Submission No.			265	
Organisation Name or Name of Submitter			RGRE Burlington Limited and RGRE Harcourt Terrace Limited (represented by John Spain Associates)

Item No.	Section Ref.	Page No.	Observation Statement	TII Response
RE: Submission on the Metrolink on Behalf of RGRE Burlington Limited (Freehold) and RGRE Harcourt Terrace Limited (Leasehold) regarding a site at 6 & 7 Harcourt Terrace, Dublin2 (D02 P0210 & D02 FH73)				
1	Introduction	3	The Metrolink line is proposed to run down Harcourt Terrace and encroaches under the front of the site at 6 & 7 Harcourt Terrace. It is acknowledged that the construction of the proposed Metrolink will have a certain amount of impact on the subject site. However, our client has serious concerns in relation to the identified noise and associated disruption contained with the Railway Order documentation. A “Significant 1” residual impact is identified to a neighbouring building (9 Harcourt Terrace). Whilst this impact is noted as being temporary, there is no clarity or estimate provided beyond this in relation to the duration of these works.	The temporary disturbance referred to is due to the passing of the Tunnel Boring Machine (TBM). Unfortu

SAINT STEPHEN'S GREEN – CHARLEMONT  
RO APPLICATION ALIGNMENT

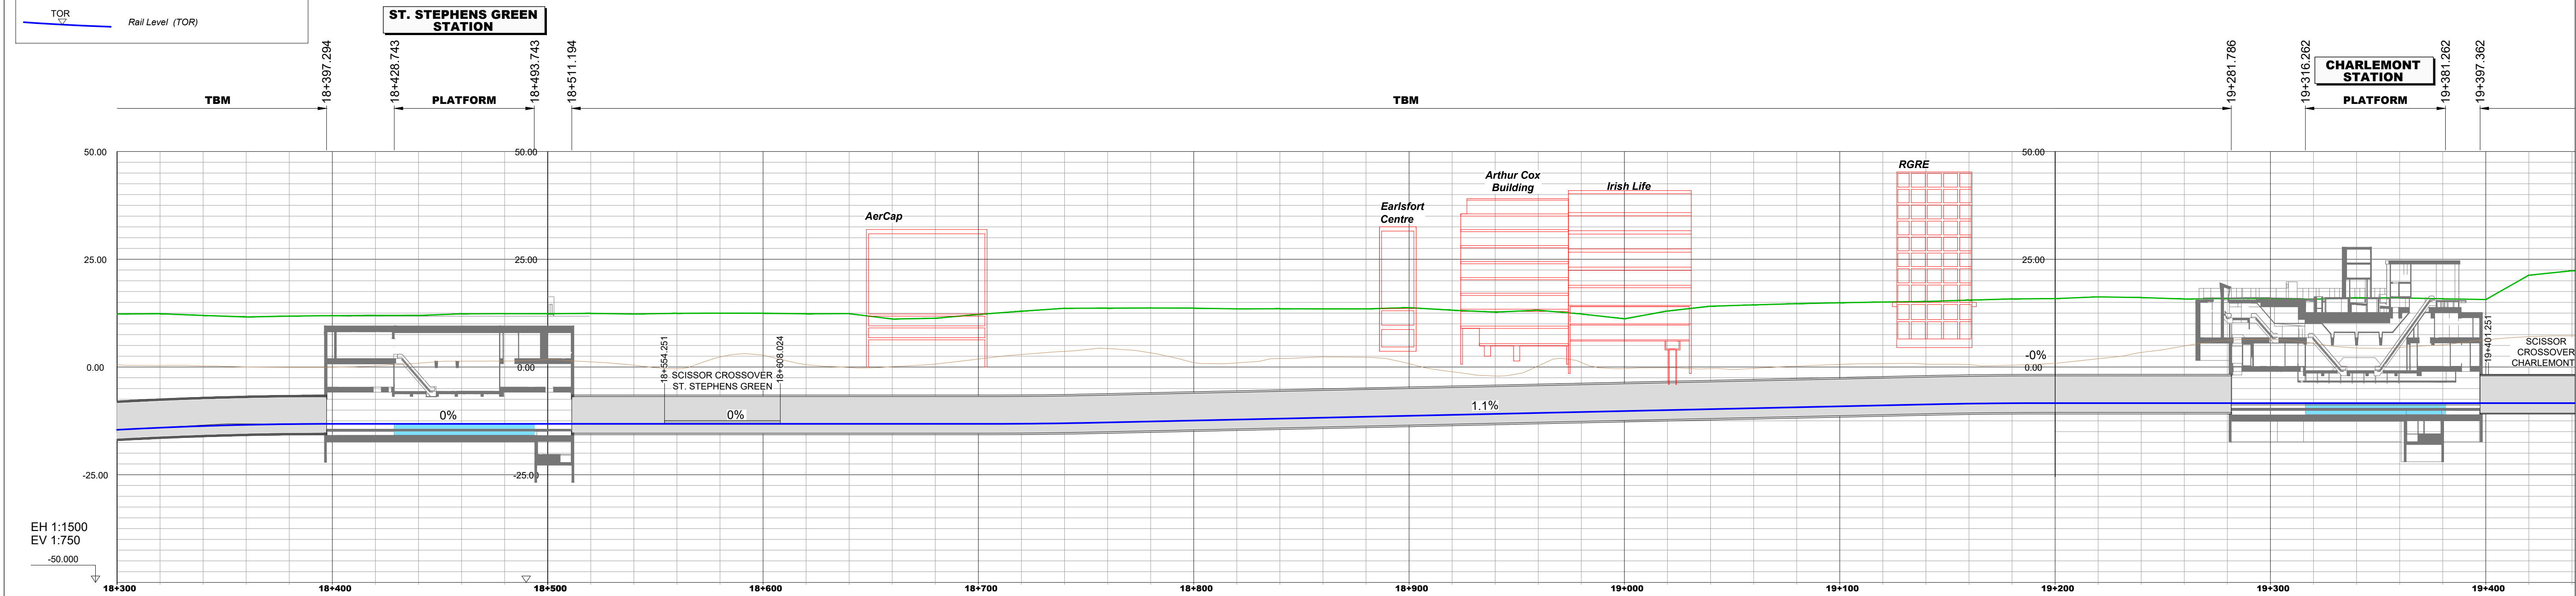
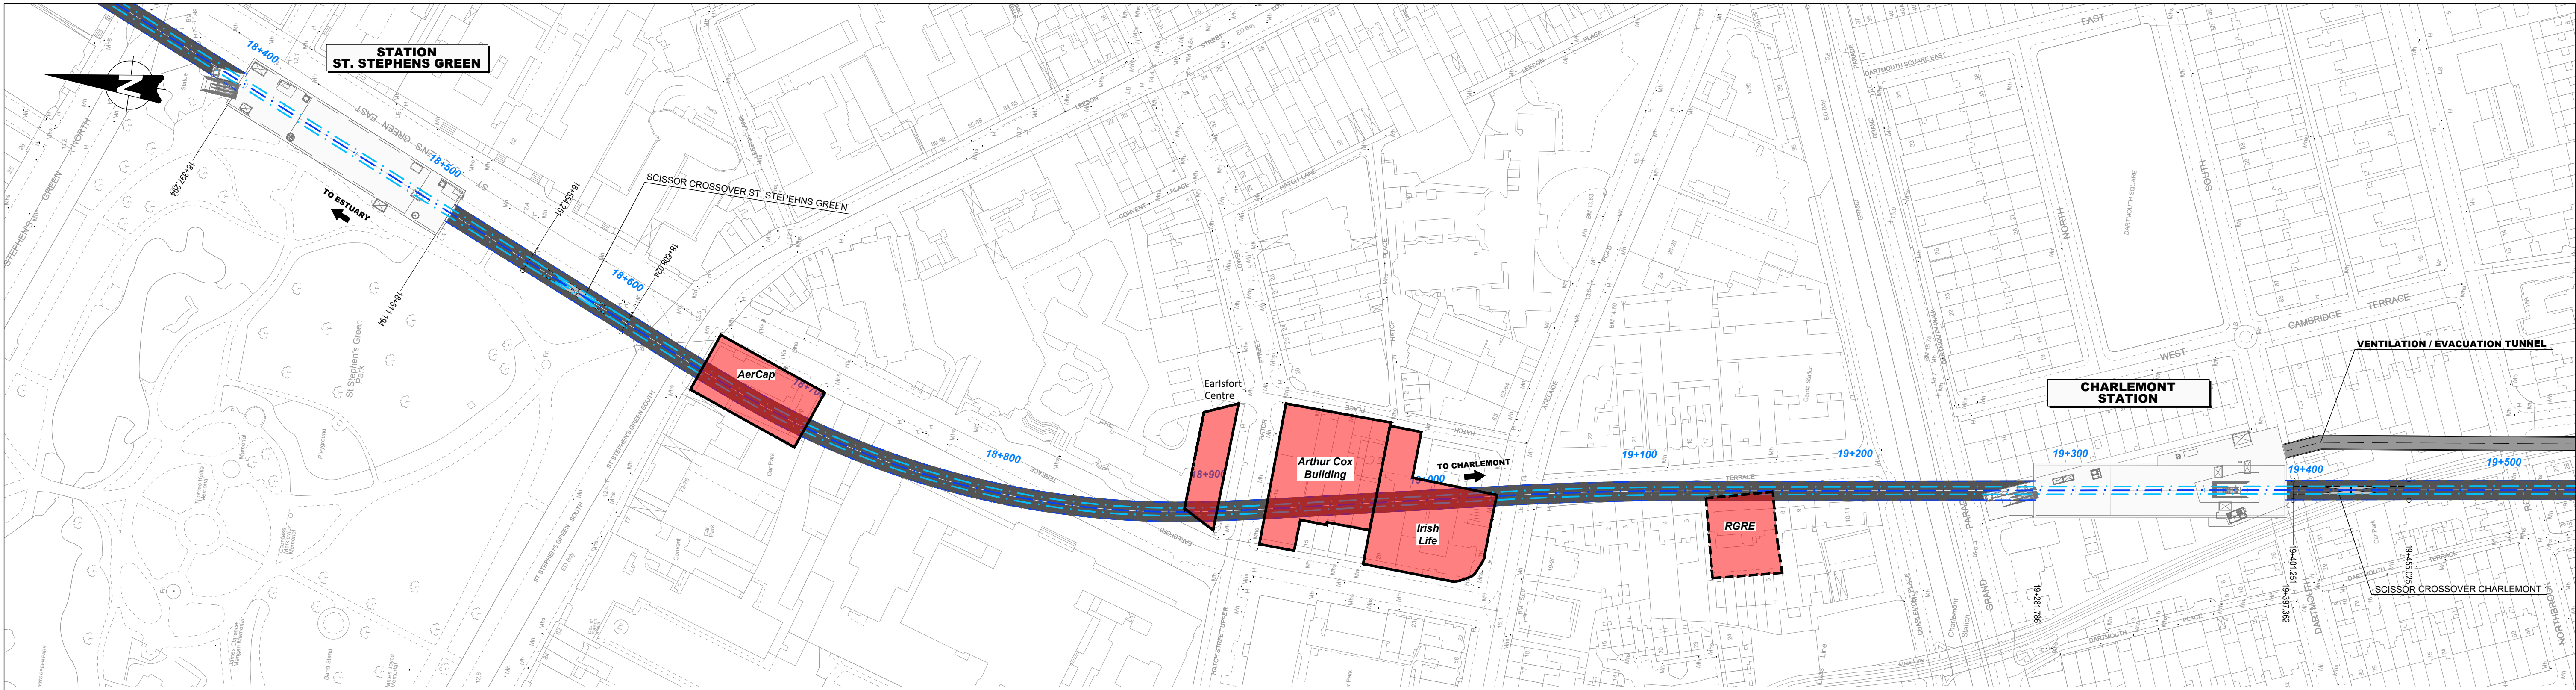
2	Engineering Considerations	3	<p></p> <p><i>"The owners of 6-7 Harcourt Terrace confirm that they are proposing to redevelop this site in the future which will include the provision of a lower ground floor and basement below existing ground level.</i></p> <p><i>We note the proposed crown of the proposed tunnel works for the Metrolink transit is at a datum of -17.3m which is at a considerable depth below the site and located in bedrock. The buildings currently on site are commercial and it would be hoped to redevelop to a height of 6+ floors.</i></p> <p><i>Therefore, the proposal to redevelop, which will include a reinforced concrete raft slab foundation supported on the underlying rock, will ensure load spread over the rock strata to minimise local future loading on the underground tunnel.</i></p> <p><i>We would request that this proposal is acceptable and can be catered for in the future. Please confirm that no vent shafts or the like to service the underground tunnels are to be located on our site as this would be problematic both now and for future development."</i></p>	<p>MetroLink will be a catalyst for and provide opportunity for future development and regeneration. While the MetroLink Railway Order does not include for future neighbouring or overhead development, the tunnels and stations are designed to support appropriate future imposed loads.</p> <p>TII will require future developers to make submissions in relation to planning applications for proposed future developments on or adjacent to MetroLink and there will necessarily be some engineering constraints (such as permissible loadings) required. However MetroLink is committed to engaging with known development proposals and new development proposals as they emerge with the intent of facilitating such developments as they emerge to the maximum extent consistent with the safe operation of the proposed Project.</p> <p>Again in common with other existing rail and tunnel projects, following the granting of the Railway Order and development of detailed design, TII will produce “Guidance Note for Developers” that will be the subject of bye-laws following the granting of the Railway Order and which is designed to facilitate future adjacent or over-site development while protecting the integrity and safety of the MetroLink works and operations. It is inappropriate and unworkable to produce this policy at this stage because it would have to be in broad terms that deal not only with the current RO proposal and any contingencies that might arise from the Board seeking revised designs or new conditionality as part of the RO application process.</p> <p>Therefore at this stage TII is dealing with known development proposals on a case by case basis, TII will work with parties in the future to assist with the wider development of sites over and above stations and tunnels. In this context TII has successfully engaged with a number of developers over the last two years to accommodate development over and in proximity to the alignment and there have been no material restrictions on development subject to the implementation of agreed design and mitigation measures and it is not anticipated that MetroLink will have a material impact on the development potential of sites above and in proximity to the alignment in future.</p>

7	Appended letter from CS CONSULTING GROUP to Ronan Group Real Estate	5	<p>The owners of 6-7 Harcourt Terrace confirm that they are proposing to redevelop this site in the future which will include the provision of a lower ground floor and basement below existing ground level.</p> <p>We note that the proposed crown of the proposed tunnel works for the Metrolink transit is at a datum of -17.3m which is at a considerable depth below the site and located in bedrock. The buildings currently on site are commercial and it would be hoped to redevelop to a height of 6 + floors.</p> <p>Therefore, the proposal to redevelop, which will include a reinforced concrete raft slab foundation supported on the underlying rock, will ensure load spread over the rock strata to minimise local future loading on the underground tunnel.</p> <p>We would request that this proposal is acceptable and can be catered for in the future. Please confirm that no vent shafts or the like to service the underground tunnels are to be located on our site as this would be problematic both now and for future development.</p>	Please refer to response (2) above.

8	Appended letter from CS CONSULTING GROUP to Ronan Group Real Estate	5	The Railway order section 6. Deviations, (d) ii. states, “deviate vertically by any distance not exceeding 5 metres upwards from the levels show on the plans” as we proposed to construct a double level basement which will be supported on the underlying rock, due to the level of the crown of the tunnel and the formation level of our concrete raft foundation, the above section 6.(d) ii. would not be acceptable, in which we would request that writing confirmation is needs to be provided by our client before on any deviations from the current -17.4 metre level below existing ground as indicated on the current sections.	<p>The design includes for a limit of deviation which is required to allow for unforeseen obstructions and construction tolerances which may necessitate a change to the alignment. In the highly unlikely event that this were to occur, any resulting environmental impacts will comply with the limits set by the enforceable Railway Order.</p> <p>TII has carried out a comprehensive set of ground investigations in accordance with relevant guidelines and best practice. It has a high confidence that MetroLink can be constructed along the proposed alignment without requiring vertical or horizontal adjustment. However, in order to guard against rare and undetectable subterranean conditions that might interfere with construction, the Railway Order provides for limits of deviation (as have other railway authorisation since at least the 1840s). The impacts of potential changes within the Limits of Deviation are considered in the Wider Effects Report (Appendix A5.19).</p>
